**Consultation Response from Mark Berry KC,
Highways Development Management**

2022/92842 The Carlton Nursing Home, 25, Greenway, Milnsbridge, Huddersfield, HD3 4RZ

Change of use and internal alterations to former nursing home (C2) to form 12 apartments (C3)

Date Responded: 26-2-2024.

REV	DESCRIPTION	DATE	DRAWN
CLIENT	Mr Nasaar		
ADDRESS	25 Greenway, Longwood HD3 4RZ		
PROJECT	Change of use C2 to C3		
DRAWING	Proposed Site Plan/ Landscaping		
DRAWN	UH	DATE	Aug 22
		SCALE	1.100@A1
DWG No.	2206/04		
STATUS	PLANNING

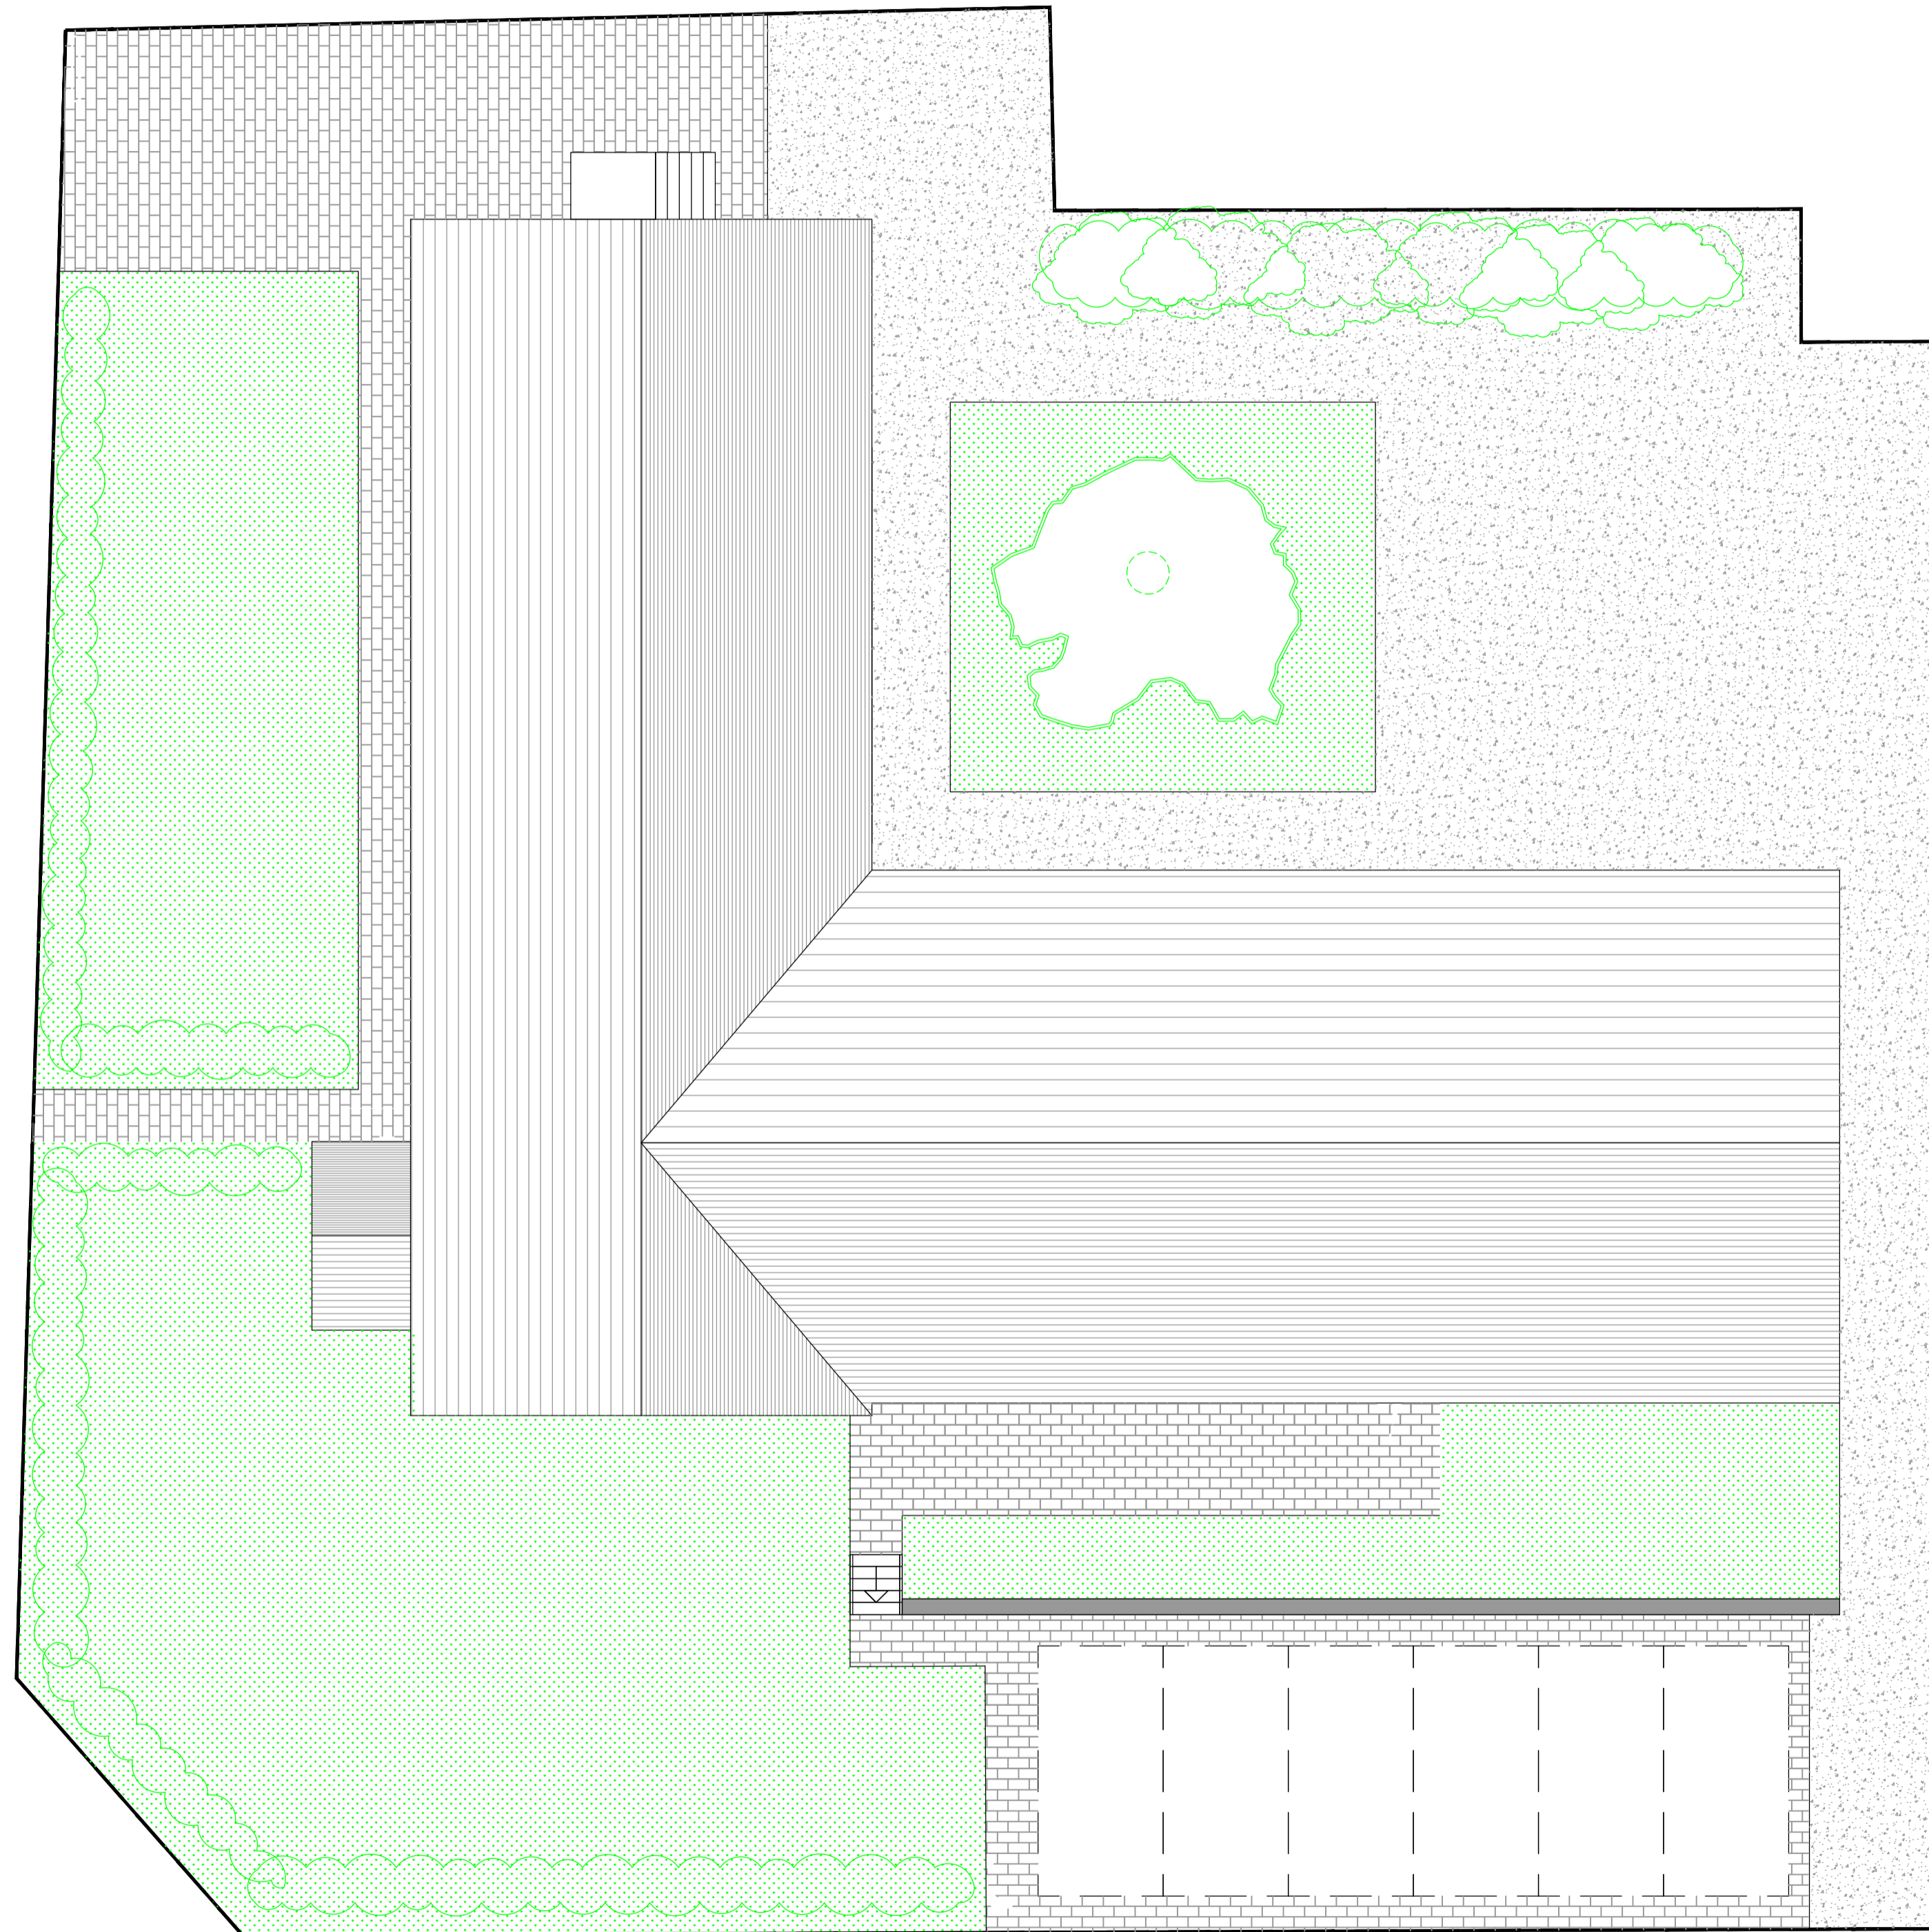
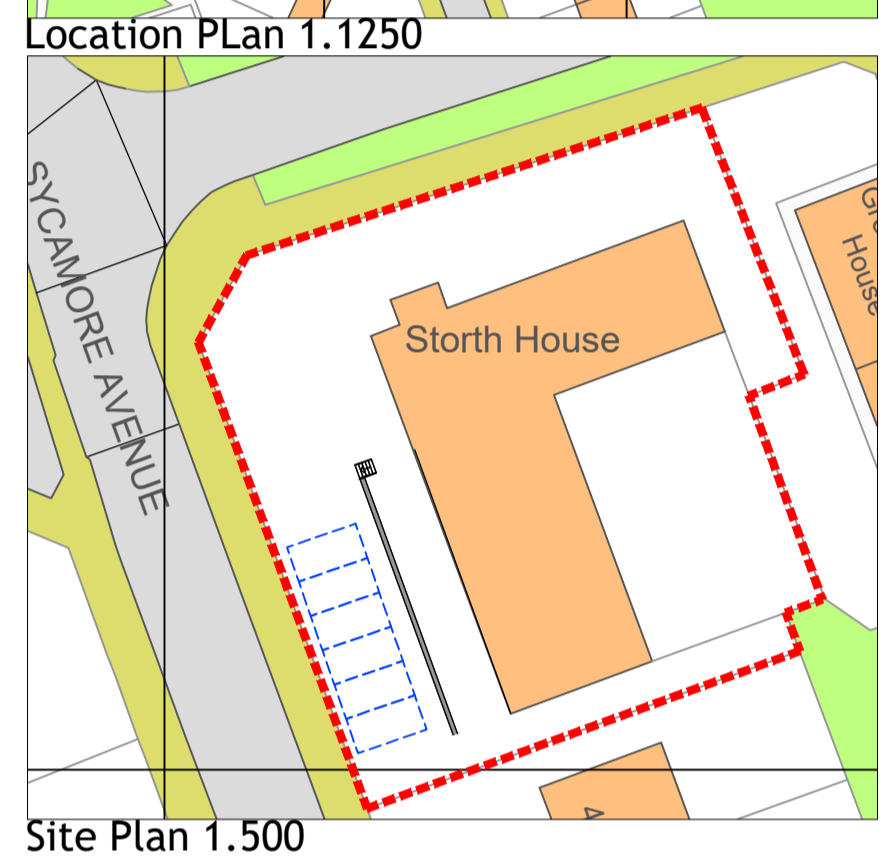
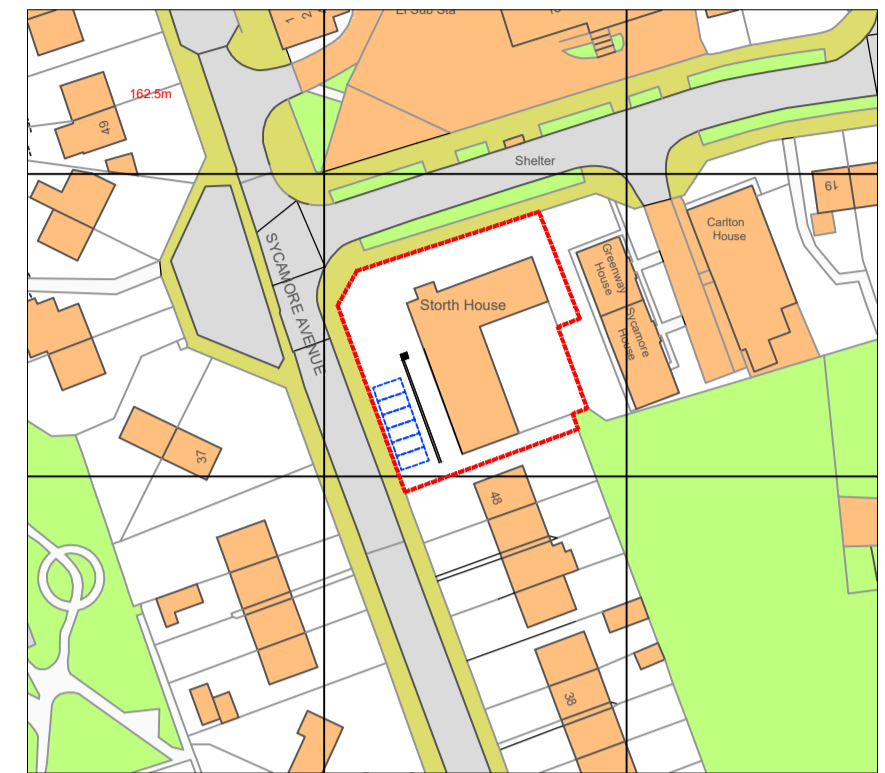
The applicants have now provided revised plan number 2206/04 showing 6 off-street parking spaces with access from Sycamore Avenue.

Whilst 6 off-street parking spaces are an under provision for 12 apartments given the reasonably sustainable location close to public transport links and that there were no off-street parking facilities for the existing use as a care home on balance Highways Development Management consider these proposals acceptable.

Areas to be surfaced and drained.

Prior to the development being brought into use, the approved vehicle parking areas shall be surfaced and drained in accordance with the Communities and Local Government; and Environment Agencies 'Guidance on the permeable surfacing of front gardens (**parking areas**)' published 13th May 2009 (ISBN 9781409804864) as amended or superseded; and thereafter retained throughout the lifetime of the development.
